Your Ref: 000014775
Our Ref: AB/143/12/ 17-12-2012
Please ask for:
Mr D Sullivan

Two new rooms in roof with new shower room and internal adaptations to the ground floor
1 Surrey Wharf Arundel

Thank you for your internet representation made on 28th February 2013 which has been recorded as '**an objection**' with the comments as follows:

Proposed plans & elevations

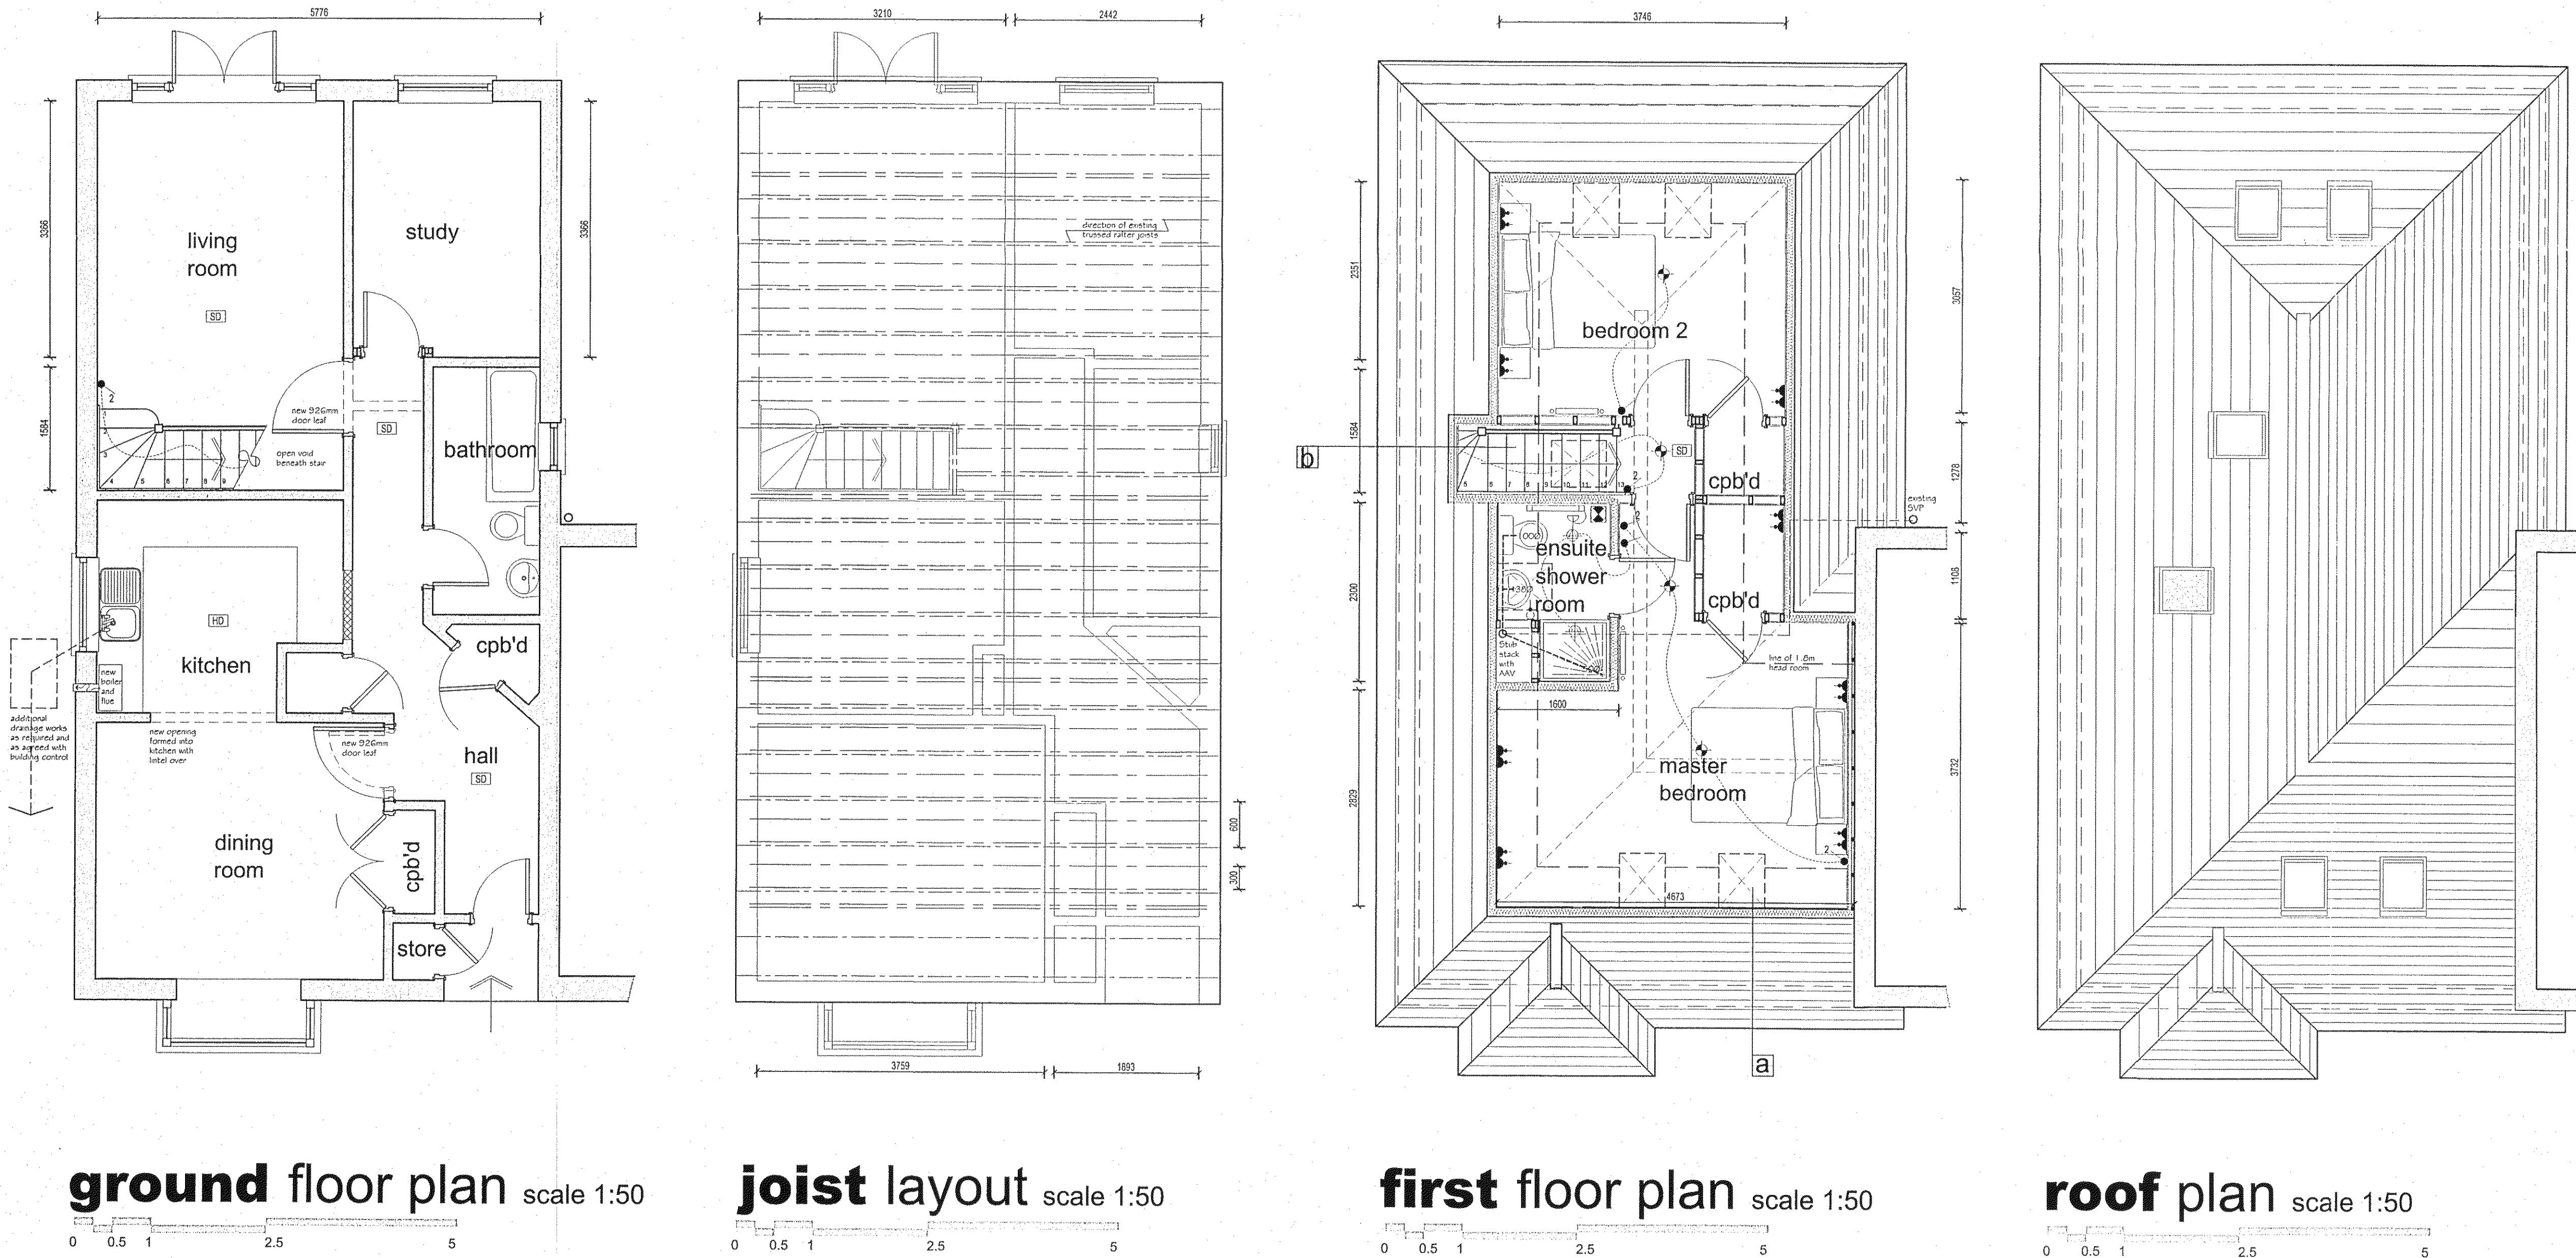
The proposed roof windows will overlook our property and next door, and in particular our already approved extension at the back with full glass back windows. The proposed windows are pvc - which is not conservation standard or befitting the Arundel plan. Furthermore, the proposed works will involve the property changing status from a retirement affordable property to a 3 bedroom property; there is demand for retirement properties in Arundel and surely we don't need more retirement complexes built but instead need to preserve the buildings within the town that are for this purpose. The current owners have parking spaces but frequently park on Tarrant street, not using their private land allocation and putting a strain on the already tight parking situation, extra rooms will provide further strain. The owners have in recent weeks accessed our land without permission and cut down trees which are not their property - which means we are now overlooked. The owners have furthermore accessed our land without permission and installed a heating pipe which pumps out over our land, without our permission and without any kind of notice. We believe that any further intrusion onto our land is not necessary and we object to the pipe which does not have permission. We live in the centre of town and outside space is at a premium, and this is very intrusive onto our seating courtyard and we are lodging an objection about this. The owners have also not got a current planning notice on view - nor have they canvassed us for our opinion, or our immediate neighbours.
